Historic England

18 October 2016

**STANDEN HALL, WORSTON ROAD, CLITHEROE, LANCASHIRE, BB7 1PR
Application No 3/2016/0886**

First Floor

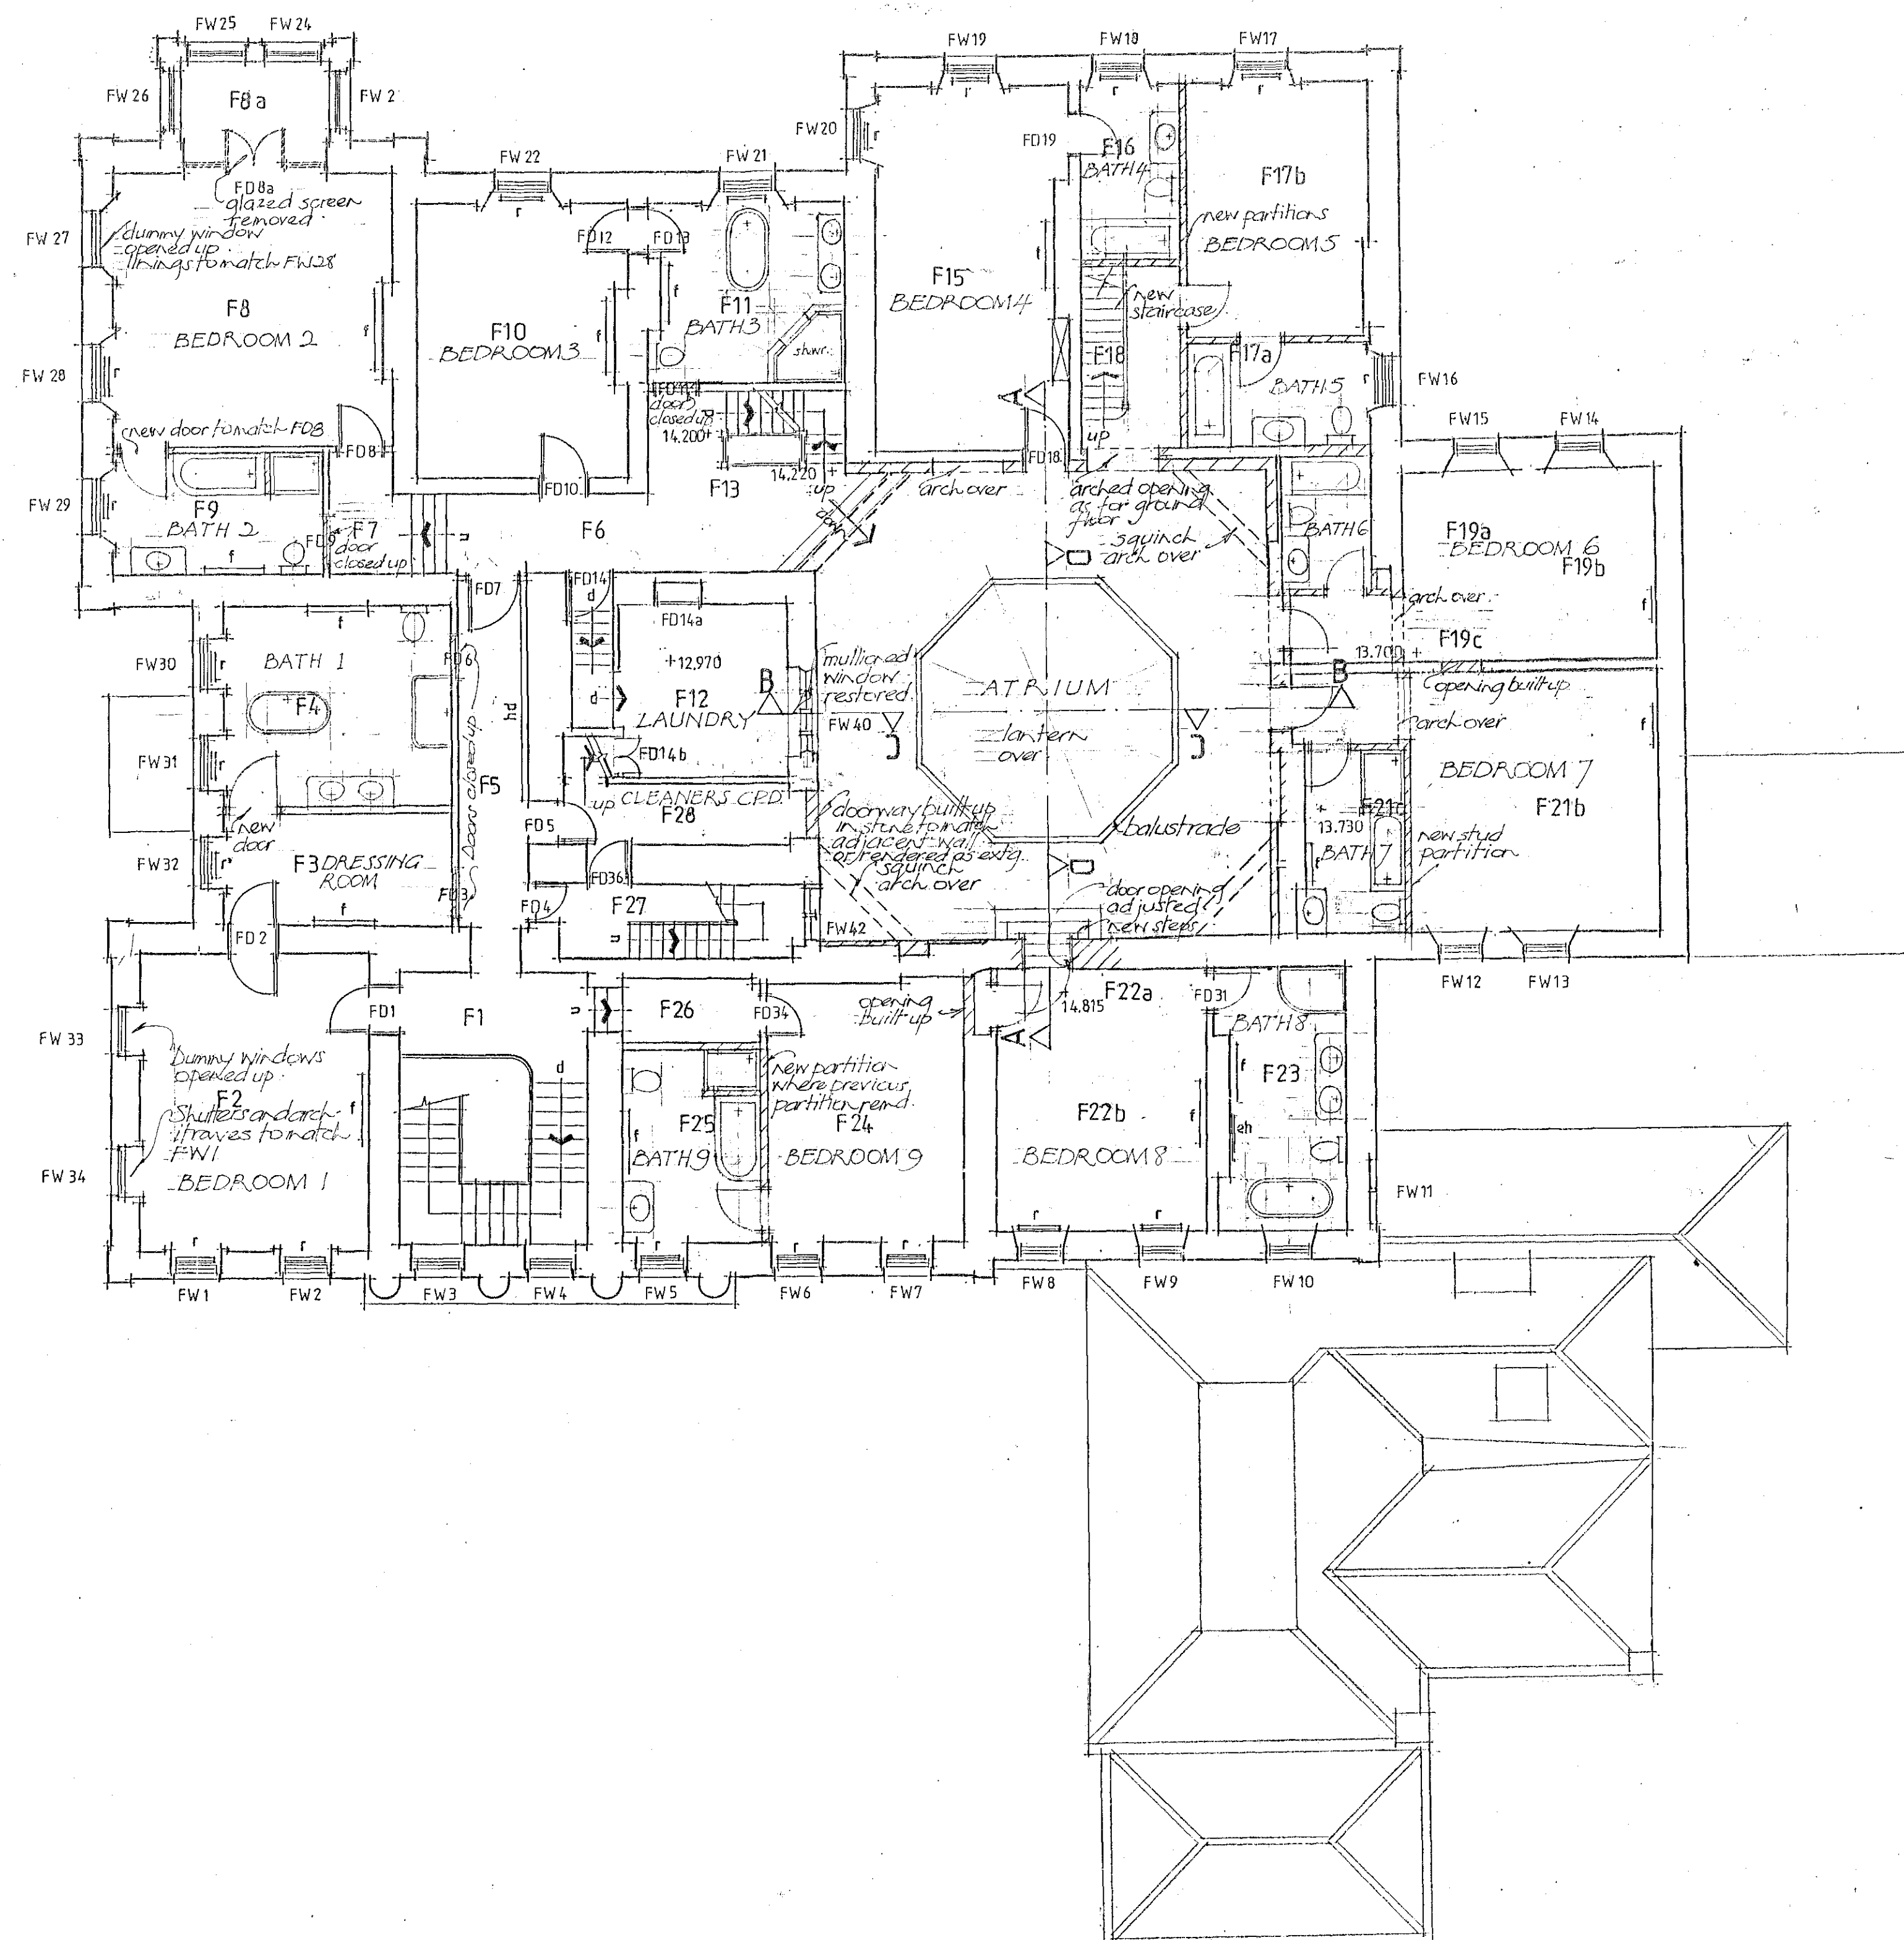
The majority of the works proposed to the existing family bedrooms relates to the aspiration to create en-suite bathrooms and in one case, a dressing room. On the whole these proposals are felt to be appropriate as doorways will be created where there is evidence of former doorways and walls are also to be reinstated. We therefore believe that the significance of the first floor rooms will be sustained as part of the proposals.

Ground Floor

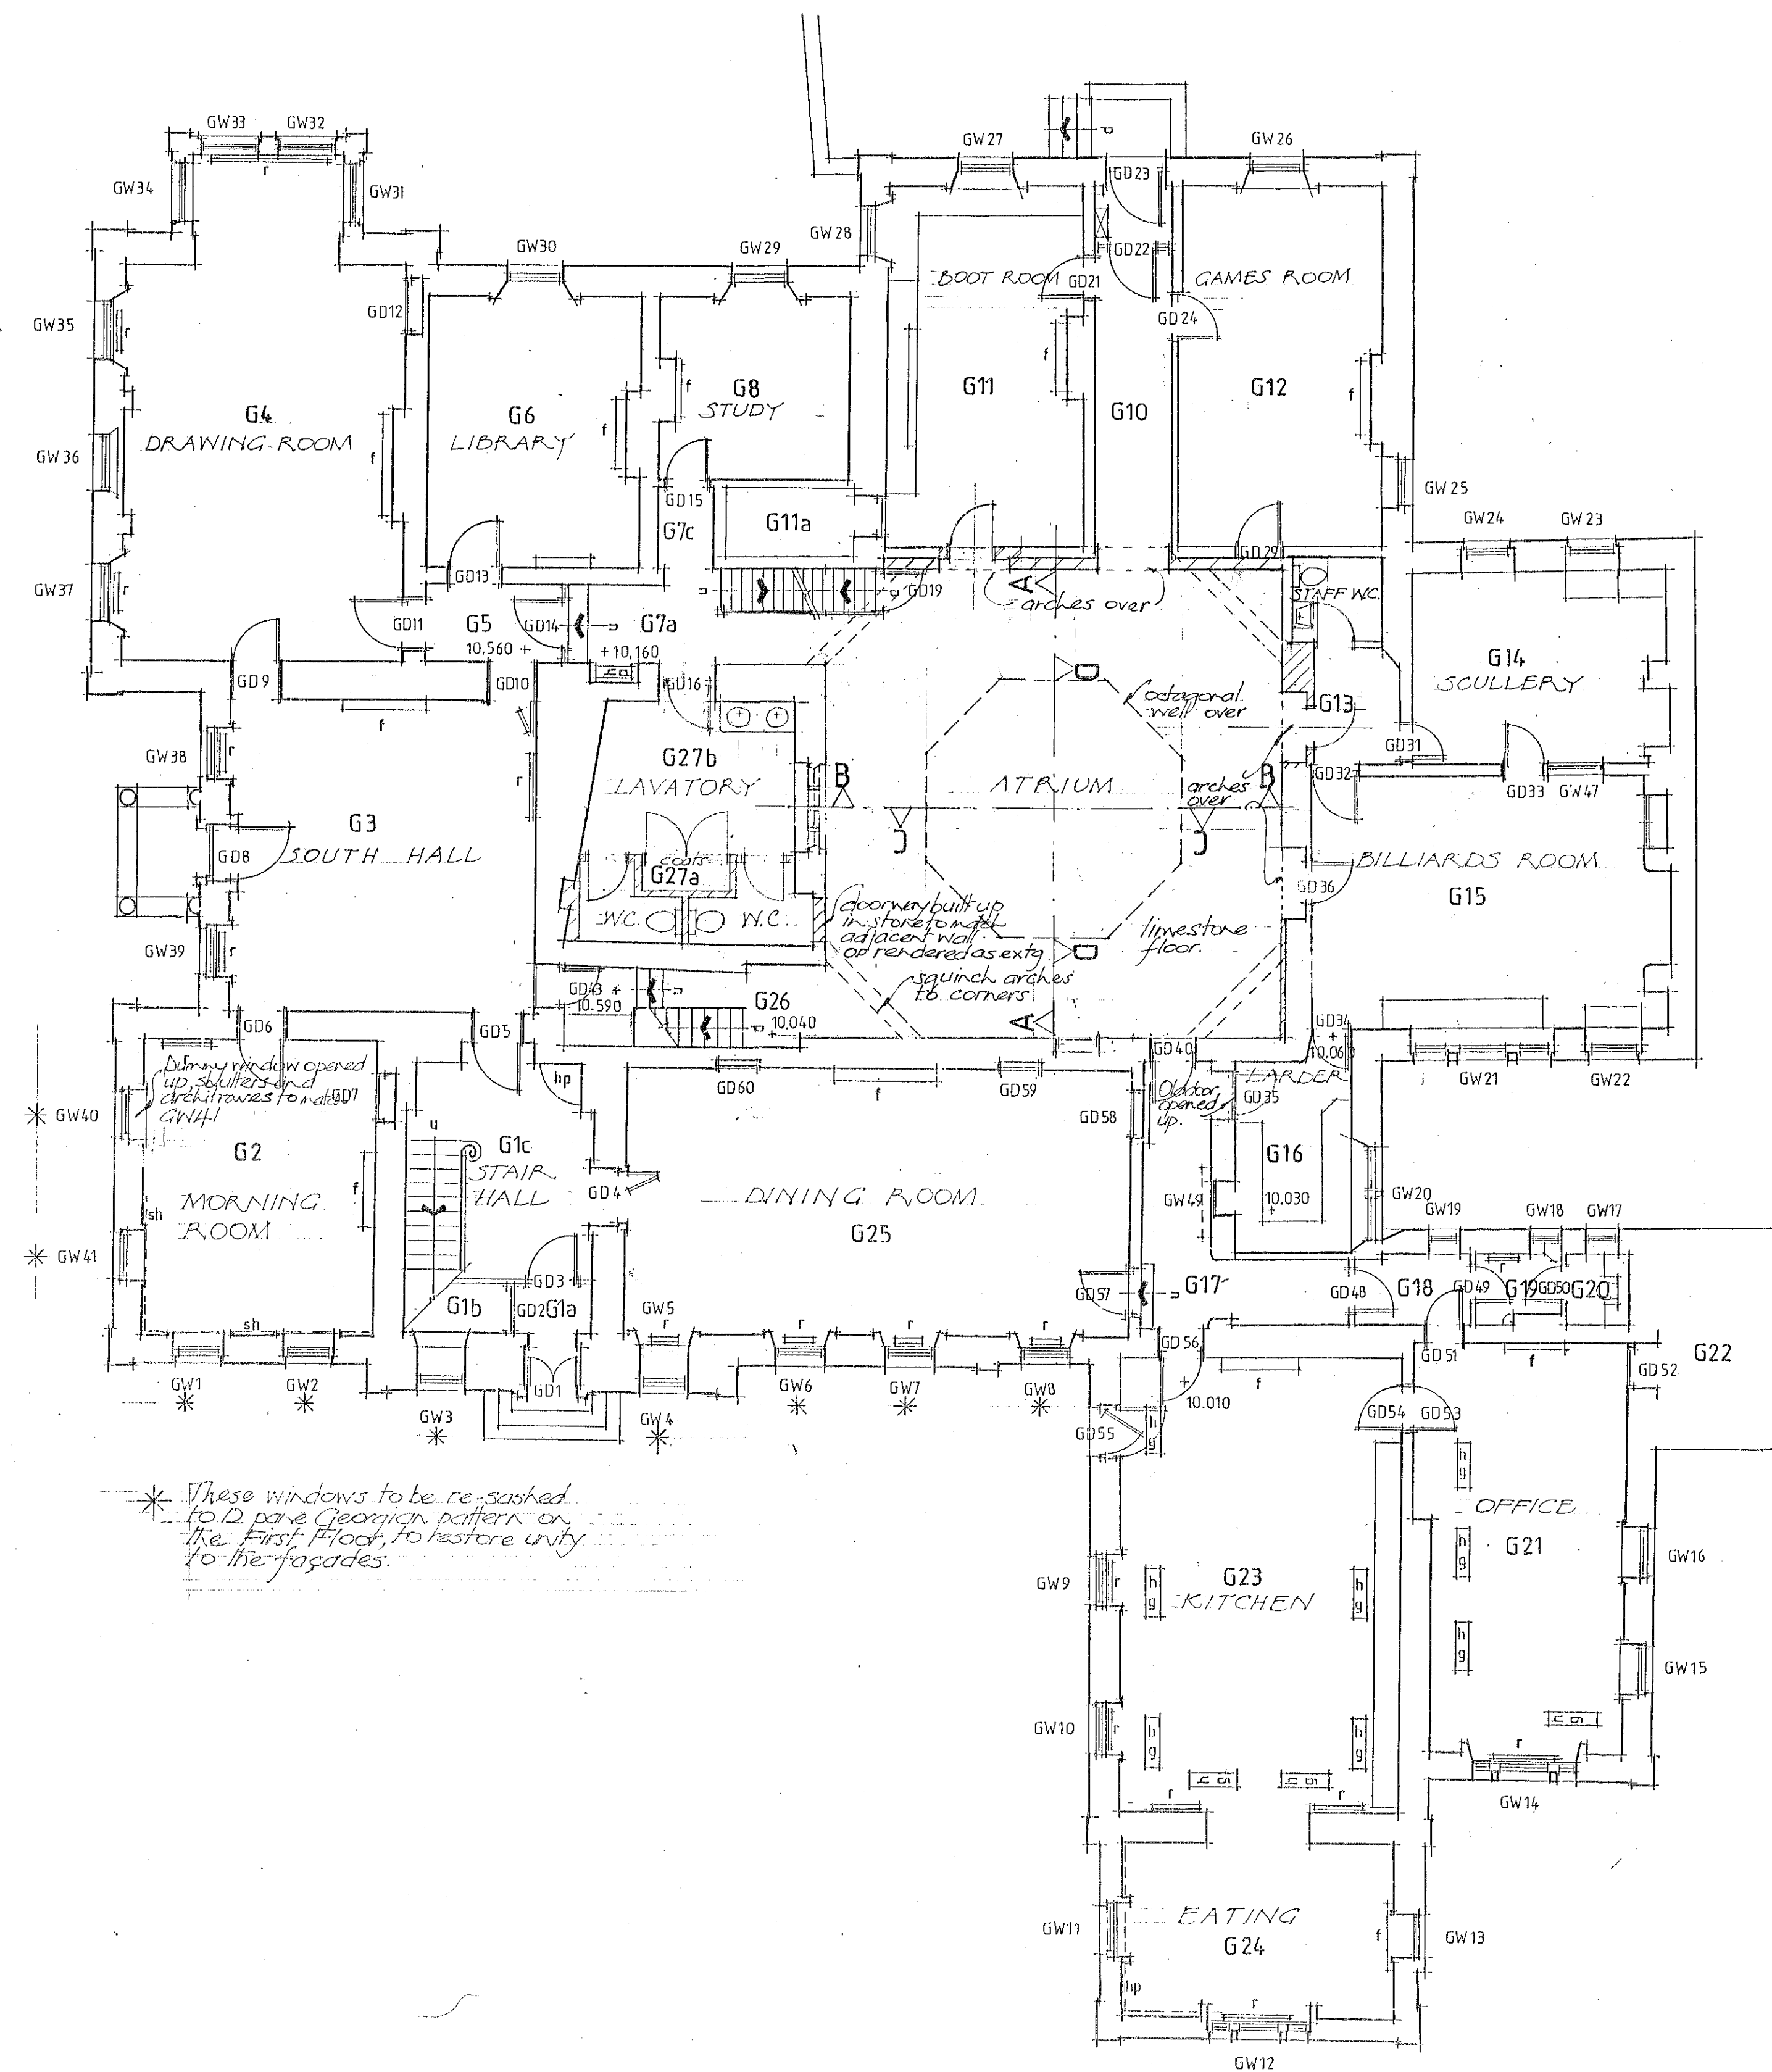
The works proposed to the ground floor are quite minor in scale. The principle family rooms remain unaltered as part of the scheme and the changes proposed to most of the north wing are changes of use rather than physical alterations to the fabric. For example, when considering the change of use of the Billiard Room to a family kitchen, as both the billiard table and the associated cabinets are freestanding, they are not considered to fall under the jurisdiction of listing, so can be relocated without the need for listed building consent. As such, it is only the intended use of the room which is for us to consider and we believe a kitchen can be accommodated in the space without harming the building, so we raise no concerns with the proposal.

The most substantial piece of work proposed to Standen Hall as part of this application is the intention to create a new atrium space in the section of the building historical given over to the circulation around the servants quarters.

These works would result in the removal of a number of servants stairs, inserted into the building in the 1890's. The Heritage Impact Assessment and Statement of Significance submitted in support of the application details how the stairs and associated corridors are only felt to be of limited significance and that because the remainder of the more significant servant's accommodation would be retained as part of the works, the hierarchy of the hall, and its interest, would be sustained.

It is advised however, that the submitted drawings showing the detailed form of the atrium are not sufficient at present and we would recommend that the Local planning authority require further details to be submitted.
